Subject: Sterling Ranch Phase II Preliminary Plan (SP-203)

The Planning Division of the Community Services Department has reviewed the Sterling Ranch Phase II Preliminary Plan, and has the following comments of behalf of El Paso County Parks. This application will be presented to the Park Advisory Board September 9, 2020.

Sterling Ranch Phase 2 Preliminary Plan Review

ADJACENT OWNERS
& OVERALL SITE
EXHIBIT

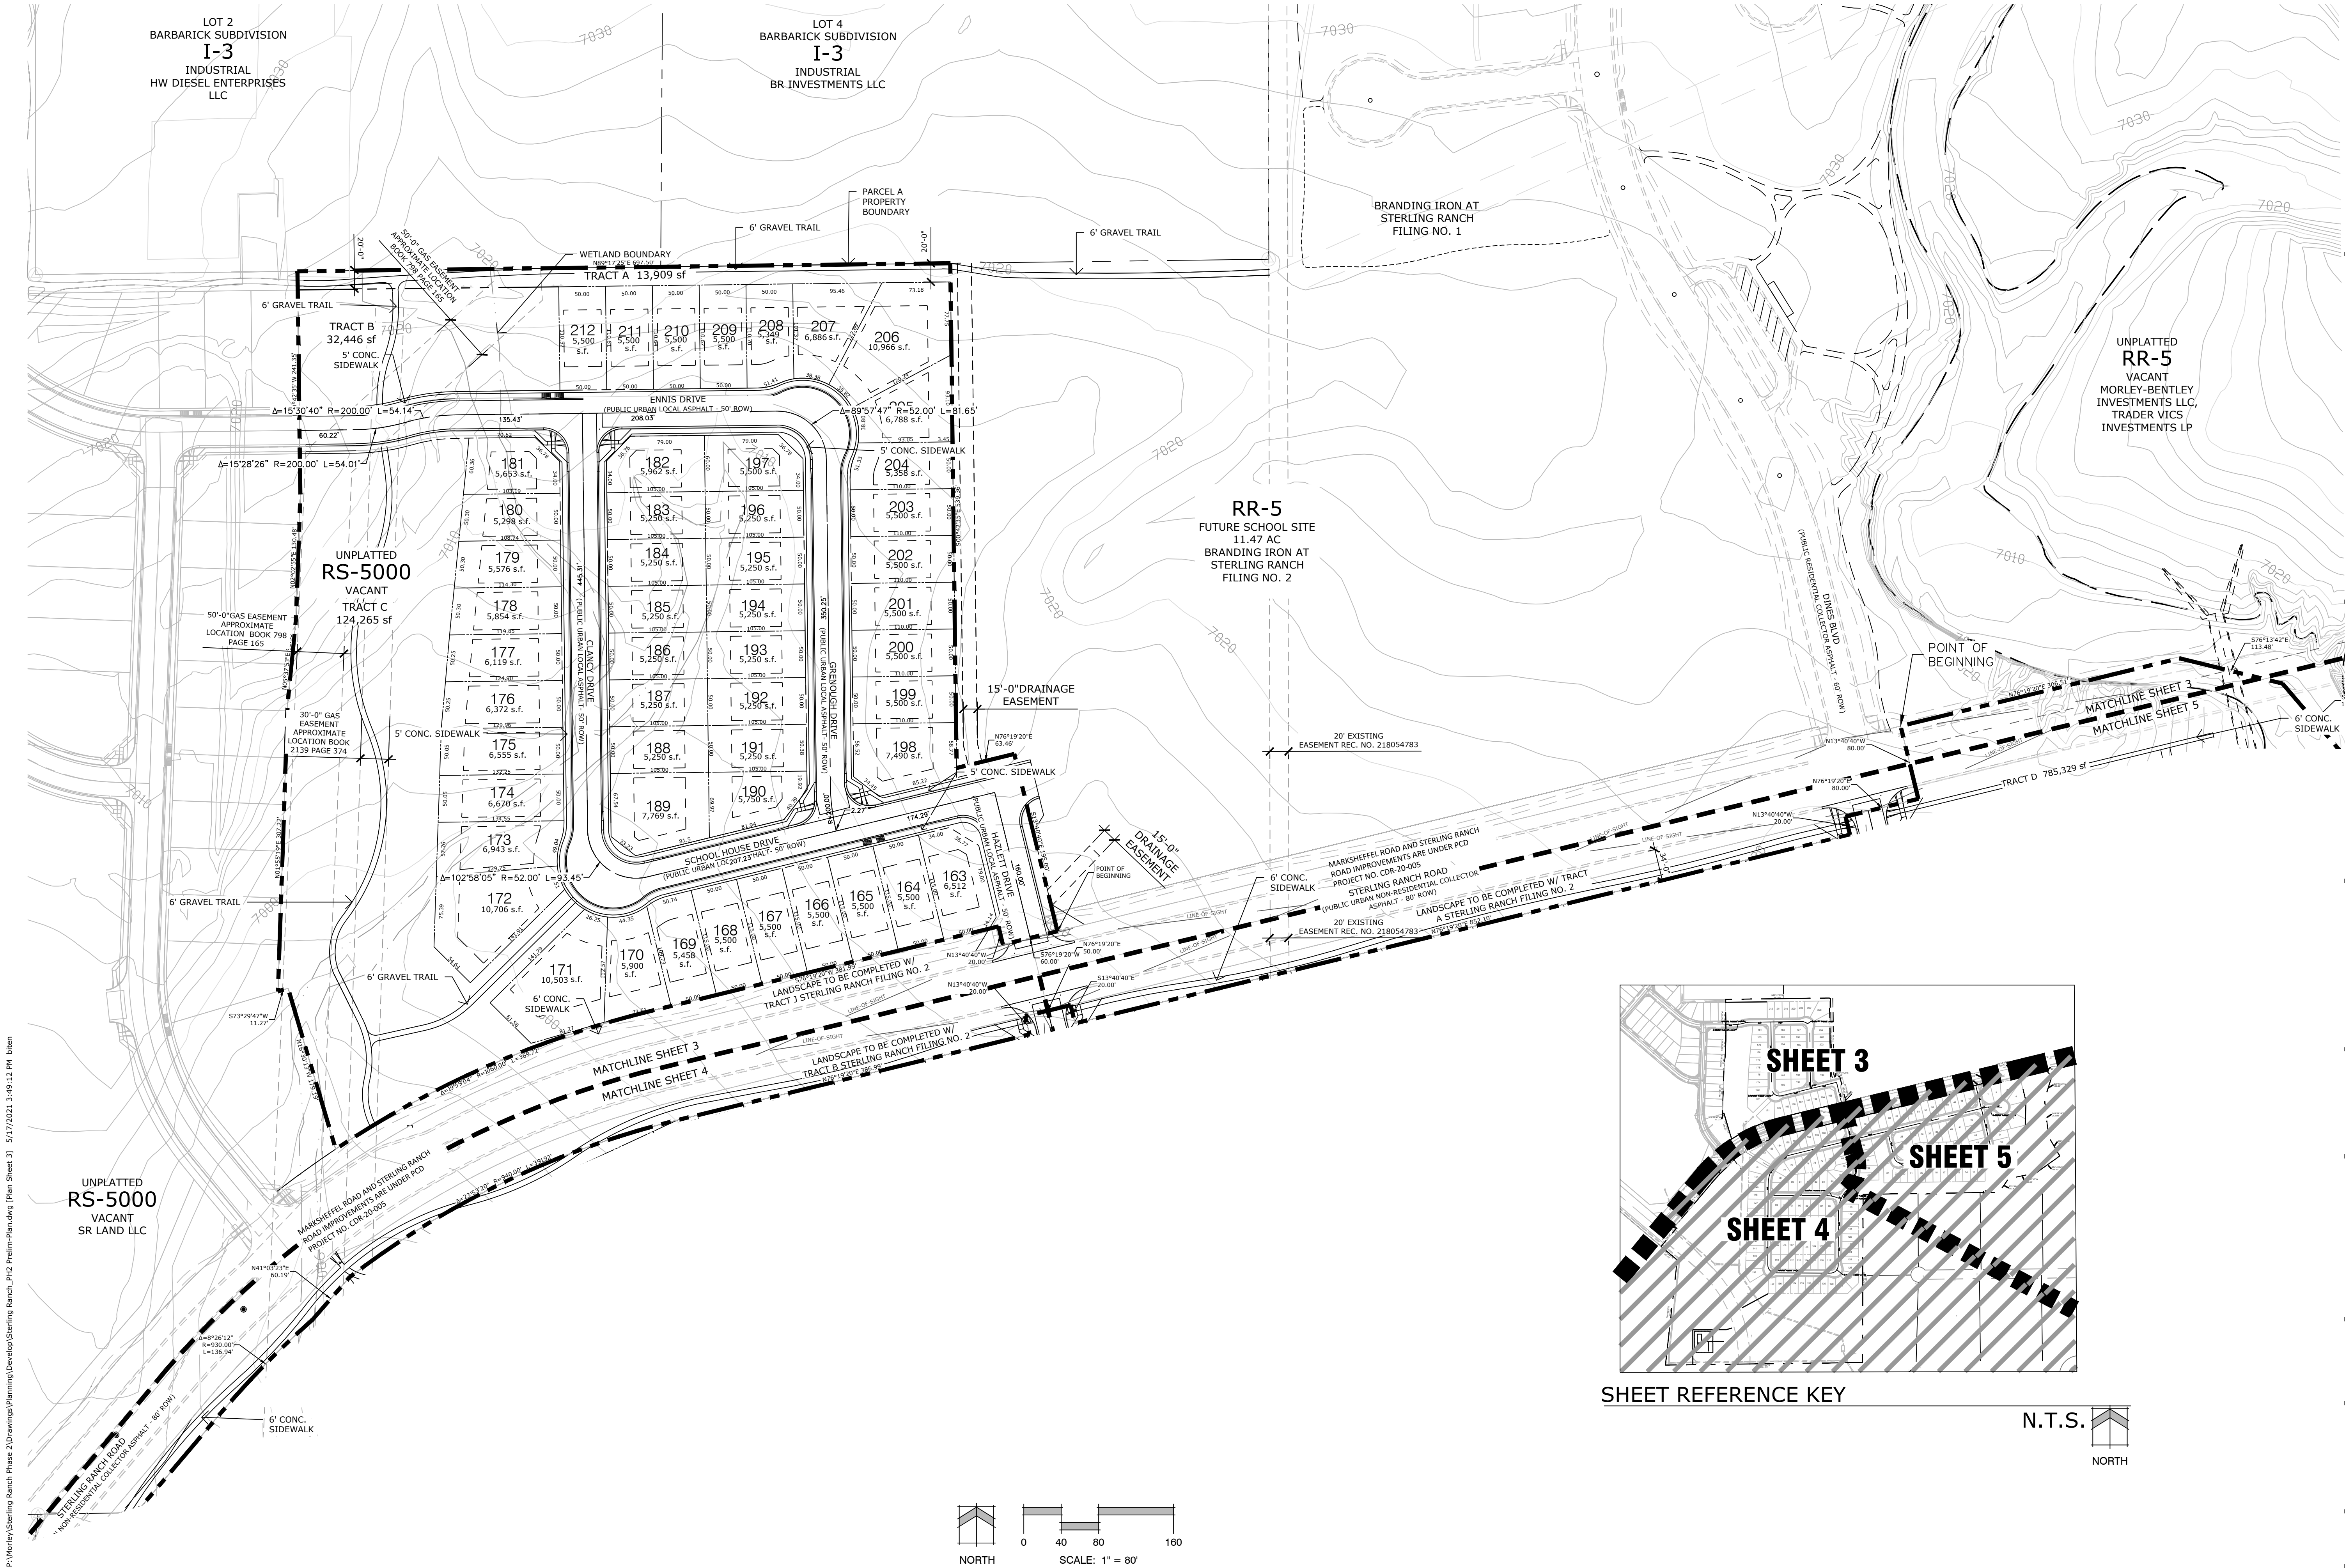
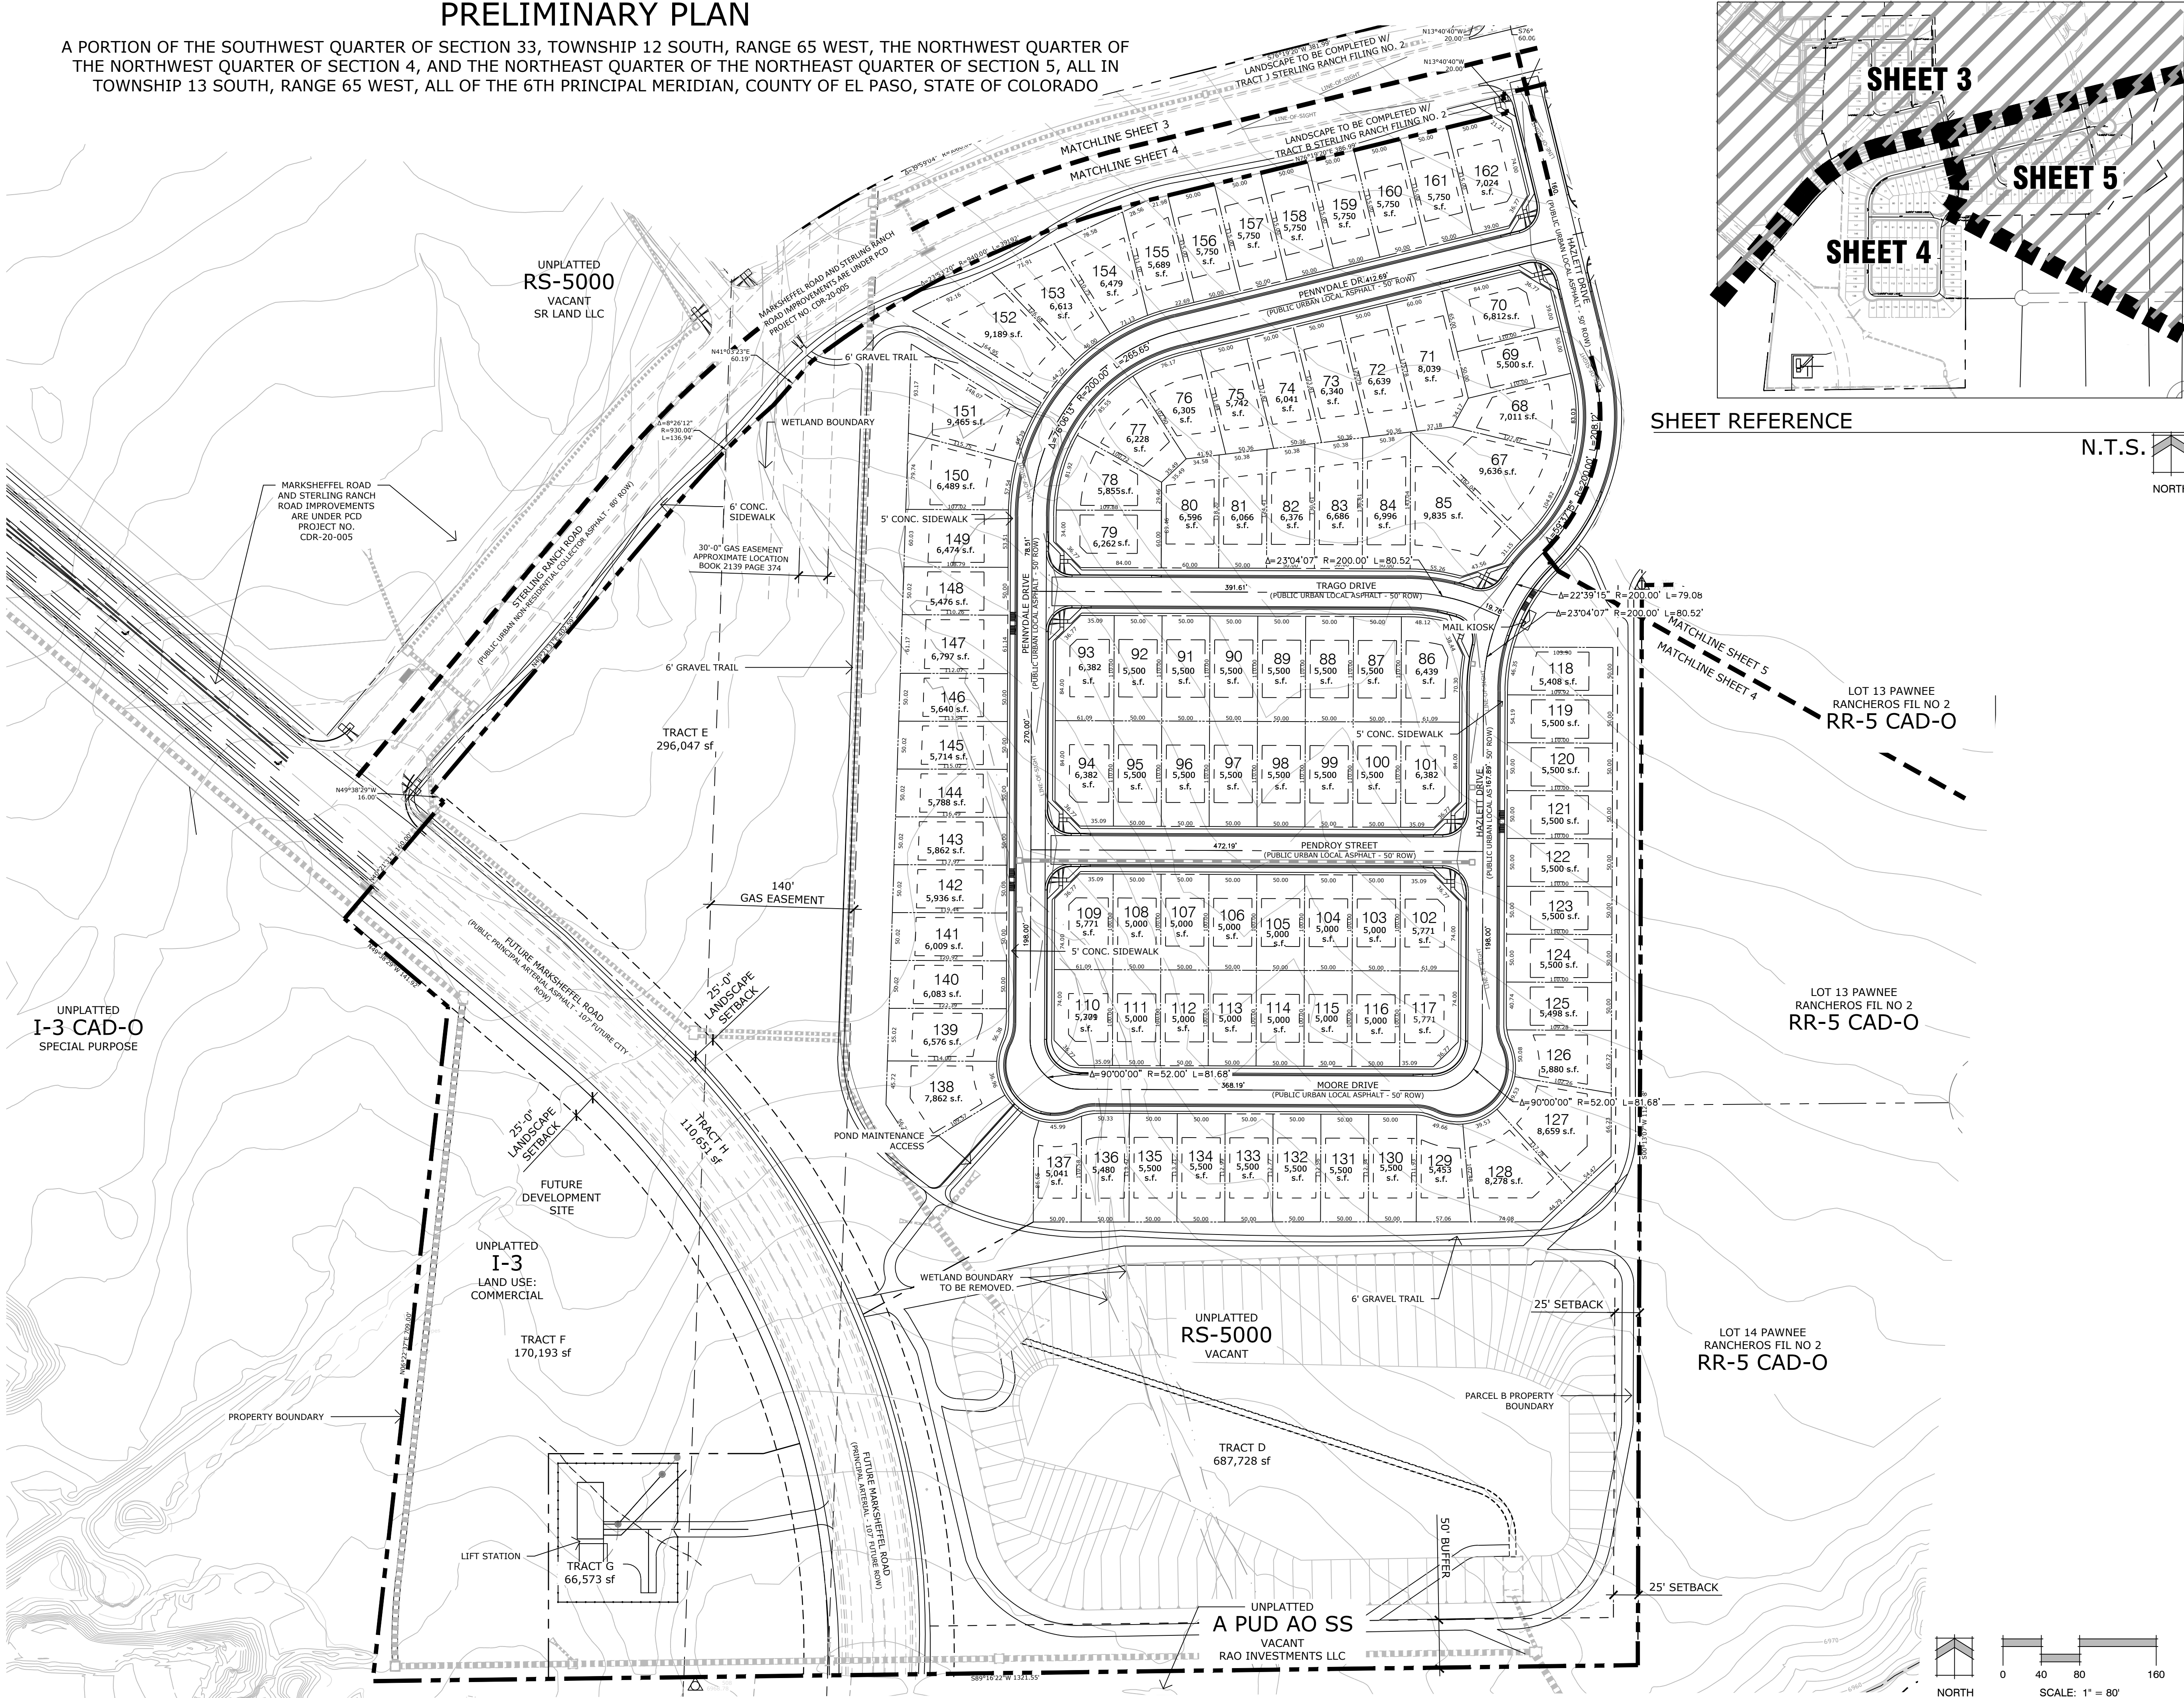
The 2013 El Paso County Parks Master Plan shows two branches of the Sand Creek Regional Trail impacted by this project. The proposed Sand Creek Regional Trail alignment bisects the eastern portion of the property, running north/south along Sand Creek, while a western branch of the Sand Creek Trail, located along a proposed extension of Marksheffel Road, will connect the primary alignment of the Sand Creek Trail to City of Colorado Springs trails located to the west of the project site.

The Preliminary Plan includes an interconnected system of trails and open space. Including open space along the Sand Creek and a connection to the proposed Sand Creek Regional Trail. Sidewalks along Sterling Ranch Road will also provide a connection to the western branch of the Sand Creek Trail, along Marksheffel Road.

Staff recommends that the developers designate and provide to El Paso County 25-foot trail easements along the Phase II section of Sand Creek that allows for public access, as well as construction and maintenance of the Sand Creek Regional Trail. Furthermore, staff recommends that the developers dedicate to El Paso County a 25-foot wide trail easement along Sterling Ranch Road for public access, construction and maintenance of the west section of the Sand Creek Regional Trail. Lastly, staff recommends fees in lieu of land dedication for regional and urban park purposes on all forthcoming final plats.

Recommend to the Planning Commission and the Board of County Commissioners that approval of Sterling Ranch Phase II Preliminary Plan includes the following conditions: (1) show on the Final Plat and dedicate to El Paso County a 25-foot trail easement along the west side of Sand Creek that allows for public access, as well as construction and maintenance of the Sand Creek Regional Trail; (2) show on the Final Plat and dedicate to El Paso County a 25-foot trail easement along the north side of Marksheffel Road that allows for public access, as well as maintenance by El Paso County of the western branch of the Sand Creek Primary Regional Trail; (3) recommend the developer dedicate to El Paso County a 25-foot wide trail easement along Sterling Ranch Road for public access, construction and maintenance of the west section of the Sand Creek Regional Trail; (4) fees in lieu of land dedication for regional park purposes in the total amount of \$99,004 and urban park fees in the total amount of \$62,540 will be required on all forthcoming Final Plat(s). A park lands agreement may be an acceptable alternative to urban park fees provided the agreement is approved by the County and executed prior to recording the final plat.
